File No: NTH22/00511/03

Your Ref: SSD-11826681

**RE: Review of Environmental Impact Statement (SSD-11826681) – Advice on EIS - HVO
North Open Cut Coal Continuation Project**

HVOP-WSP-55.01.02.02-TR-0001

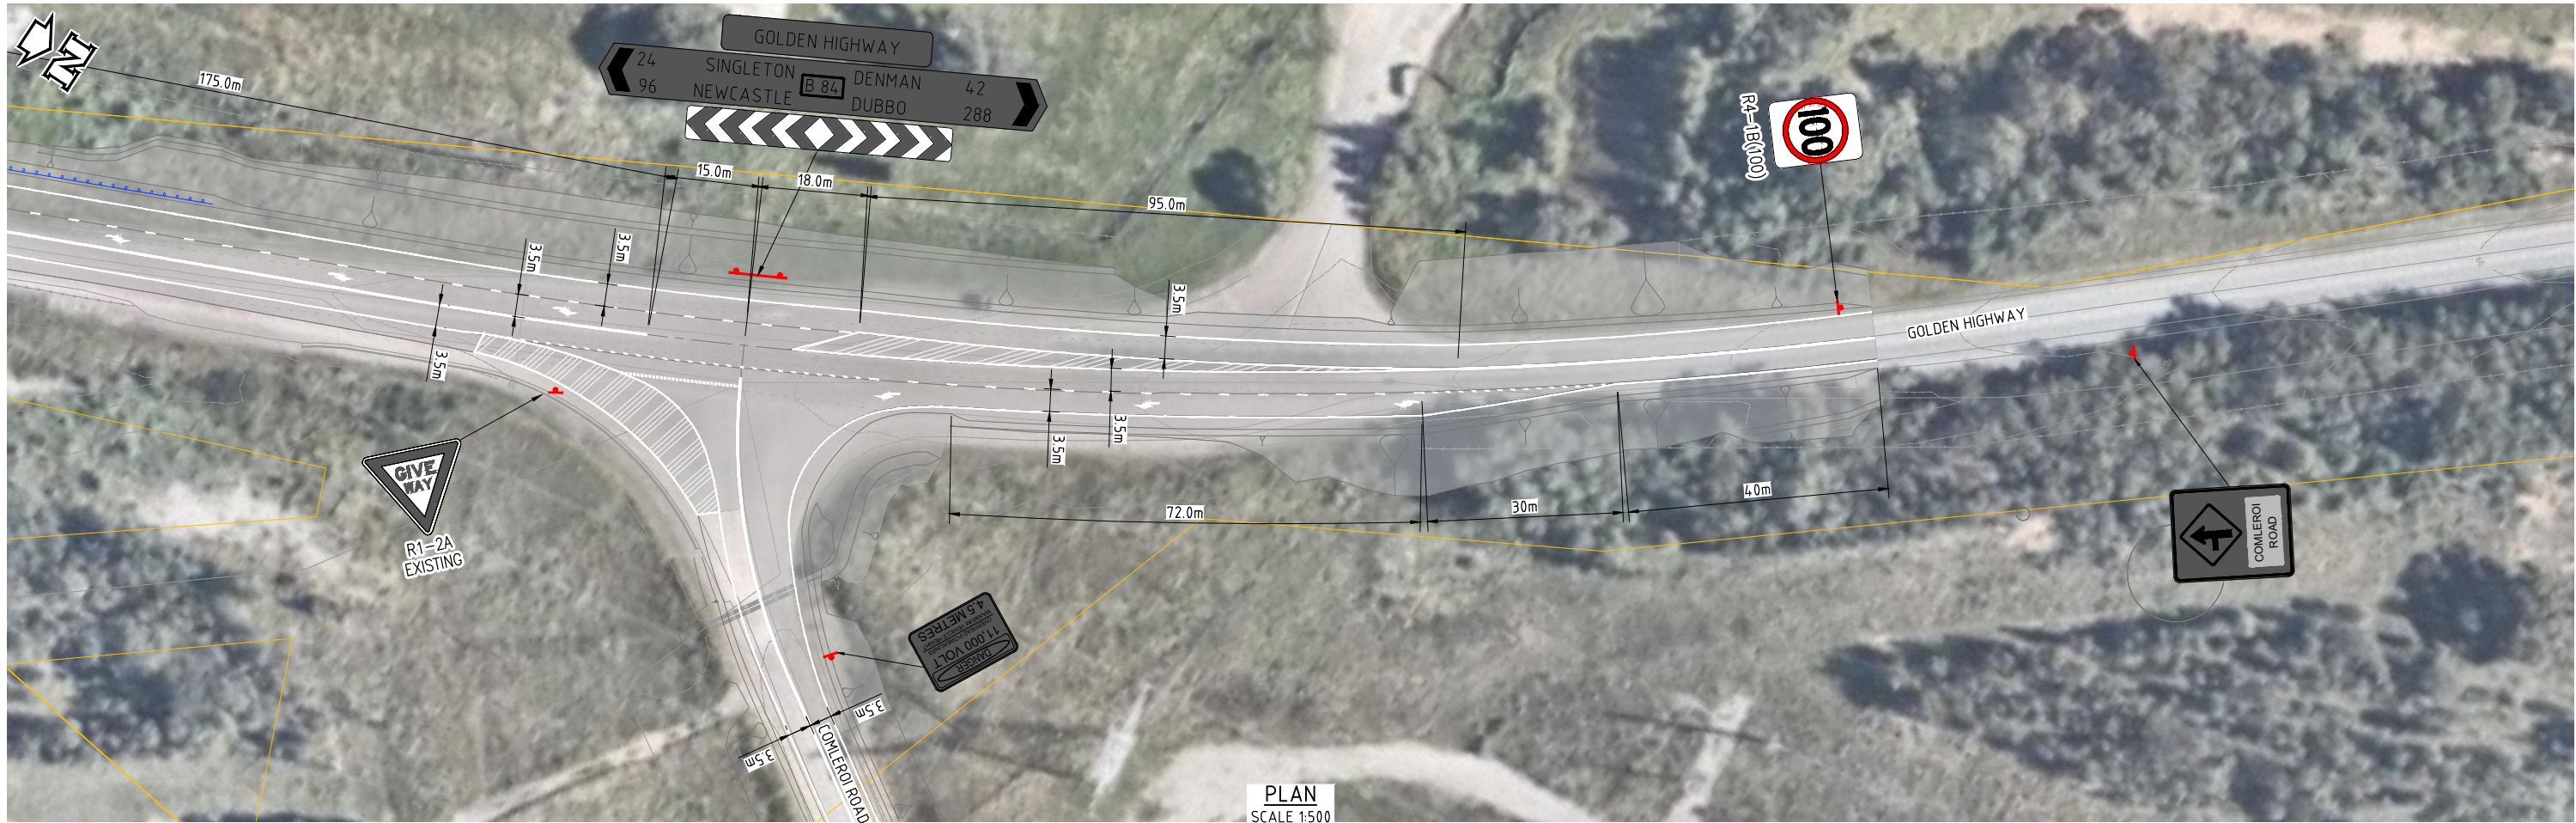
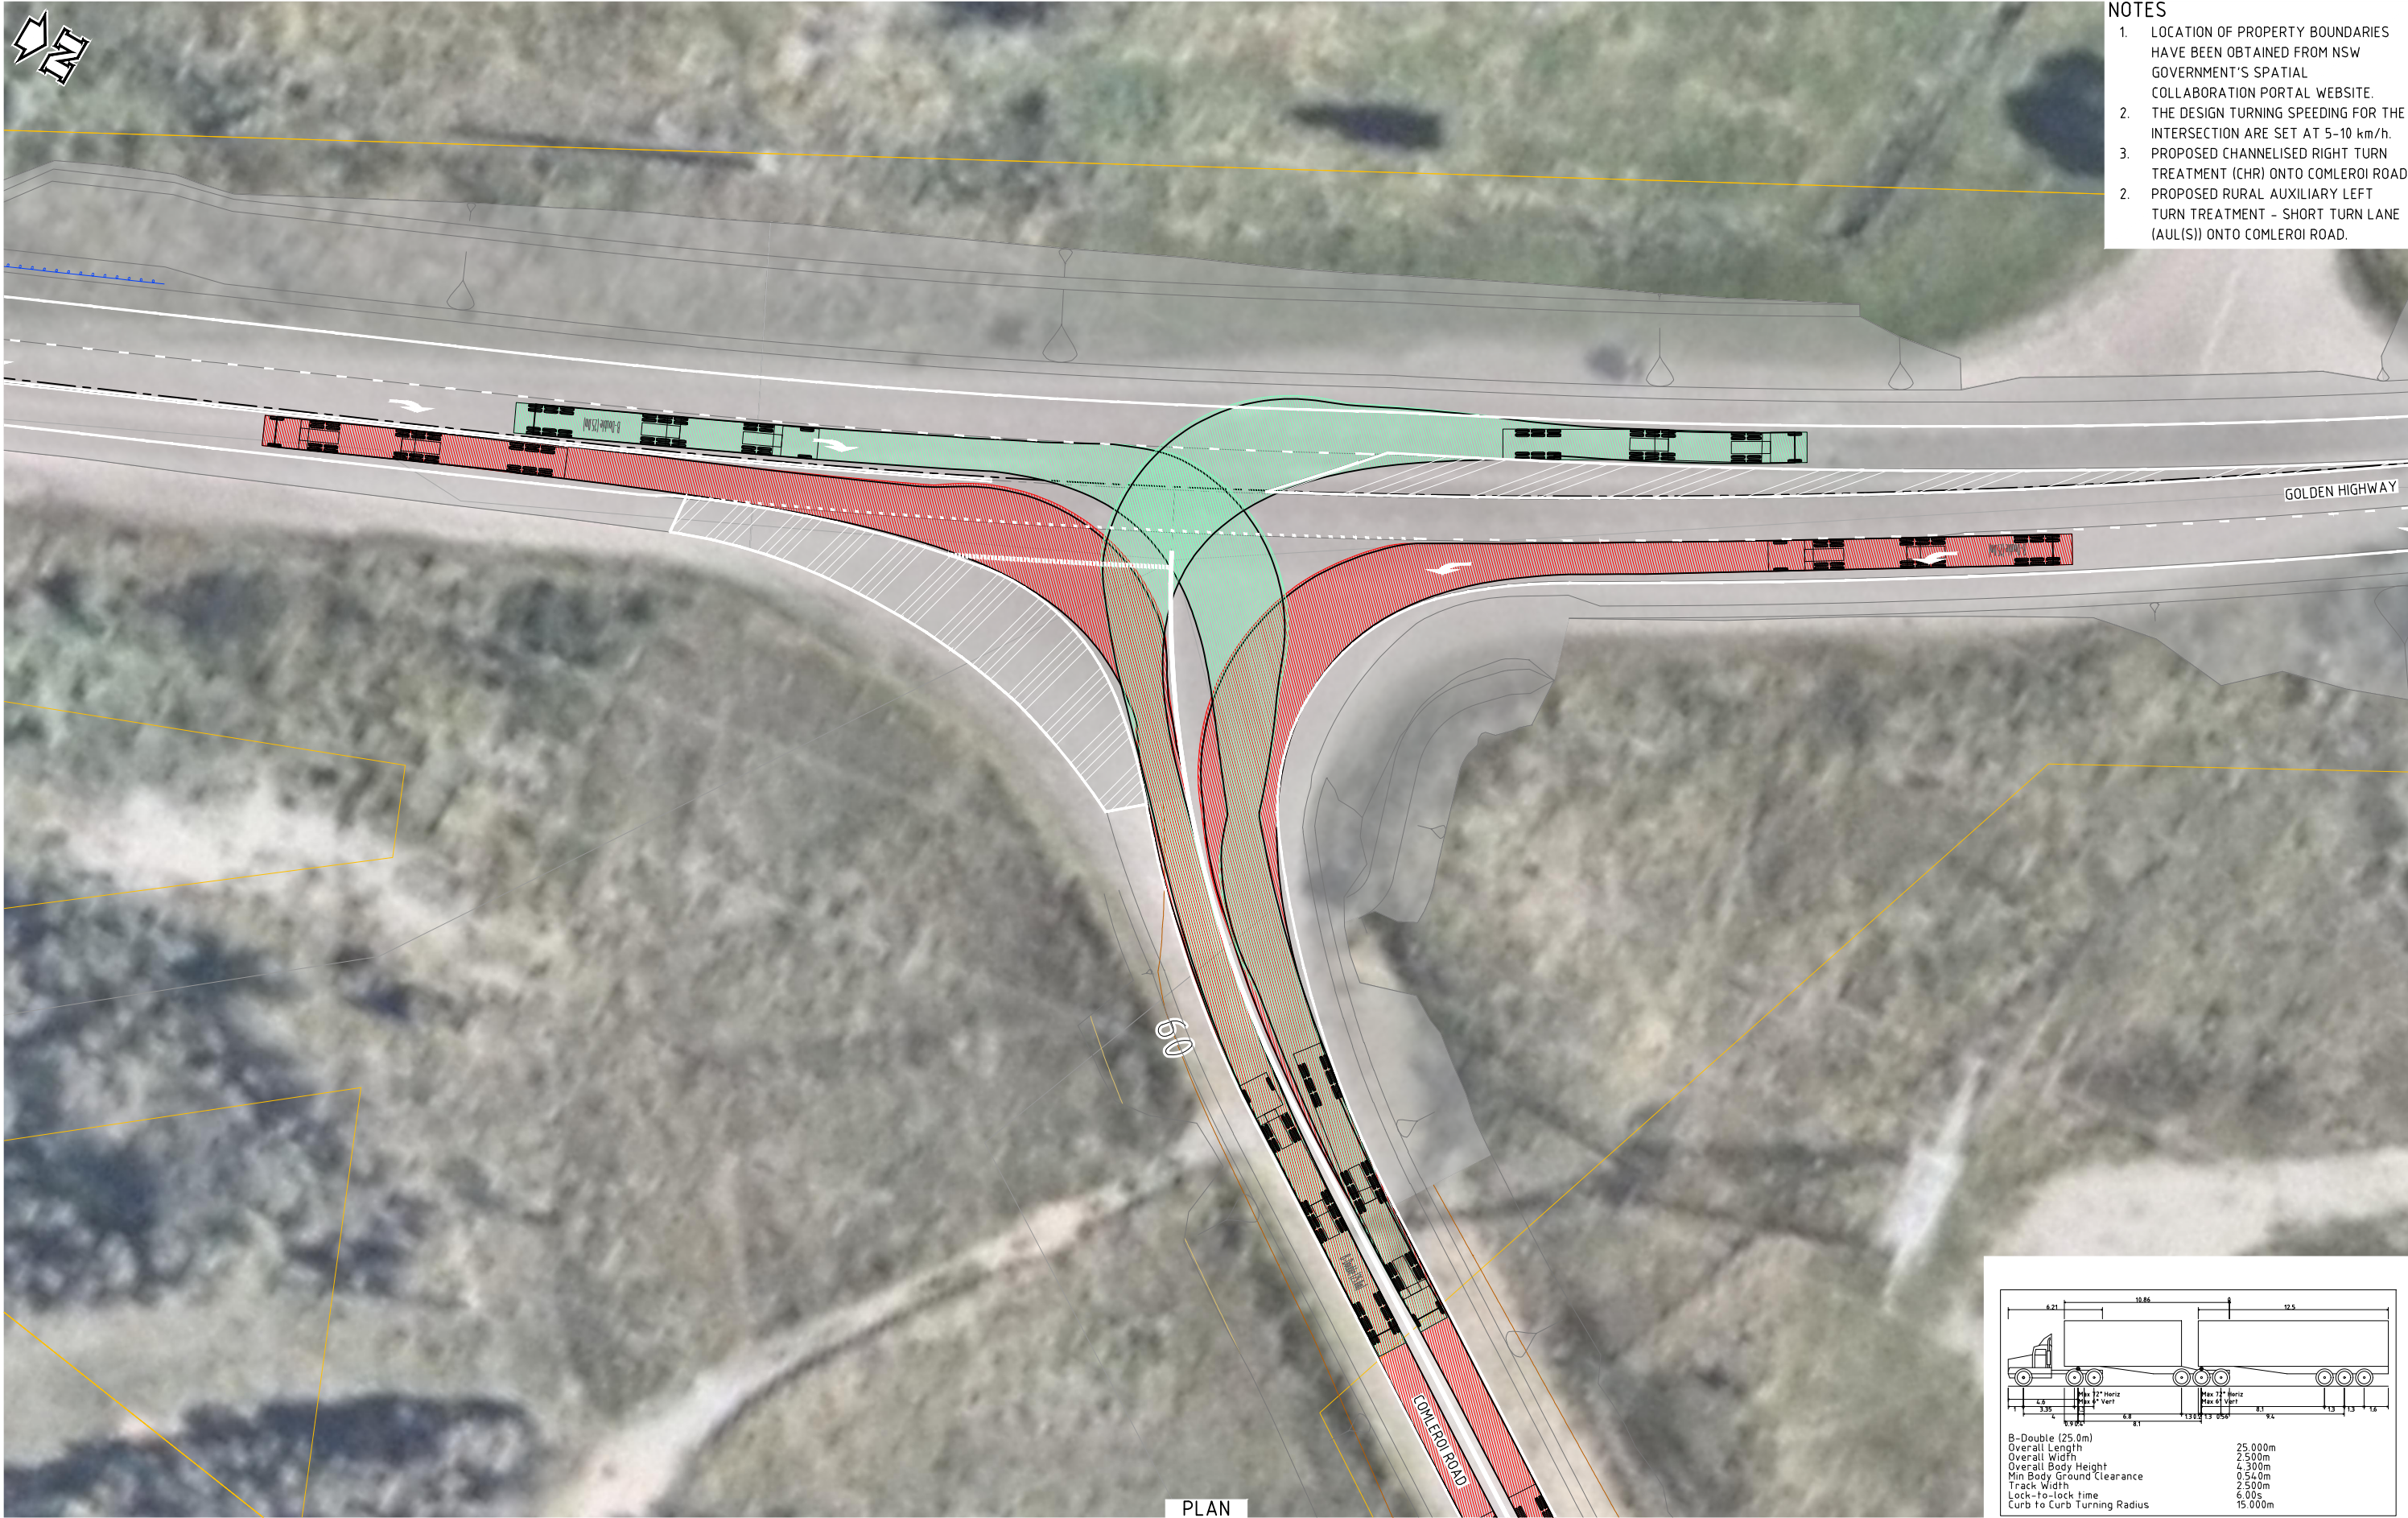
A Strategic Design of the nominated intersection upgrades at Golden Highway / Comleroi Road is sought in line with [TfNSW requirements for DA's](#). TfNSW highlights that in determining the application under the *Environmental Planning and Assessment Act 1979*, it is the Consent Authority's responsibility to consider the environmental impacts of any roadworks which are ancillary to the development. This includes any works which form part of the proposal and/or any works which are deemed necessary to include as requirements in the conditions of project approval.

Figure 2 - Lemington Road Realignment

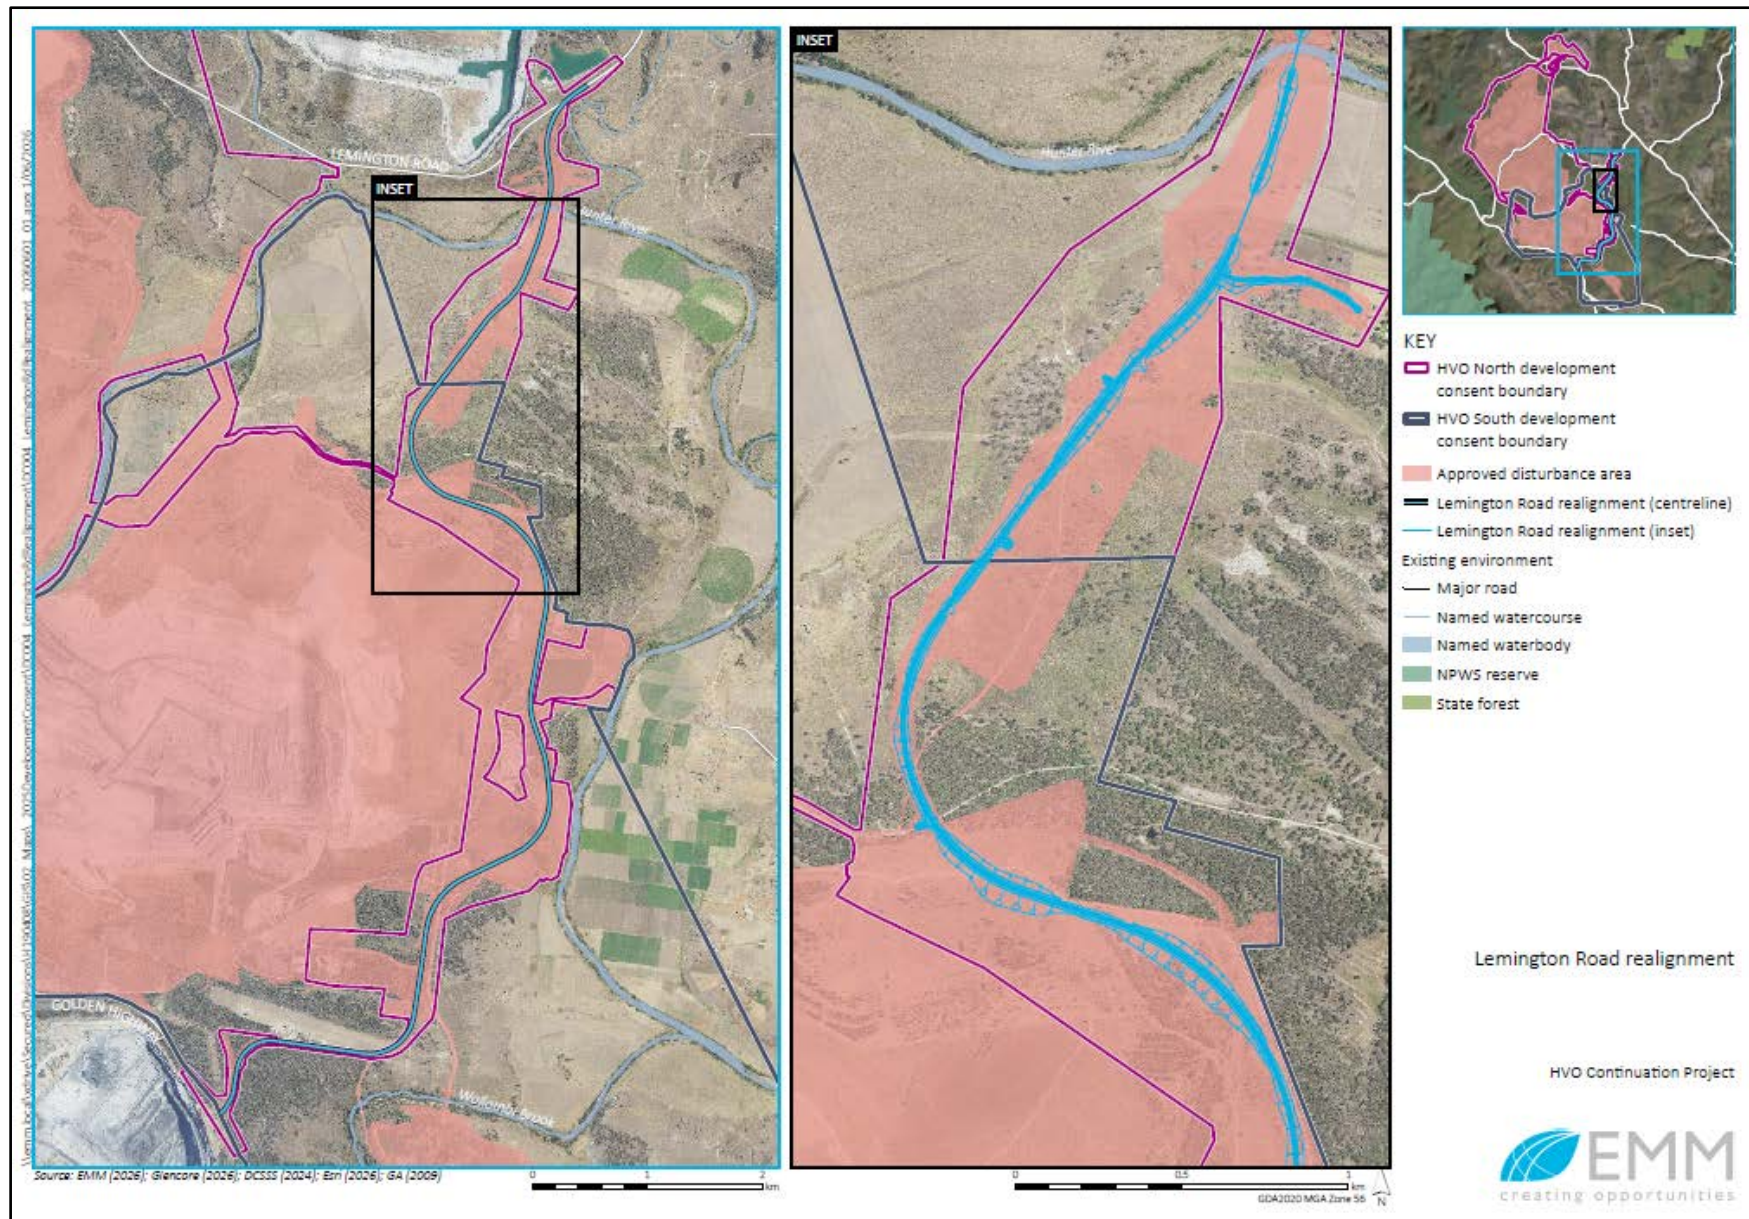
- With the realignment of Lemington Road, Council will need to consider the design of the road and target level of freight access.
- Additional commentary is sought as to why the 6-7am peak was used noting that slightly higher traffic volumes were identified between 5-6am. Is this the time that the employee shifts start and finish?
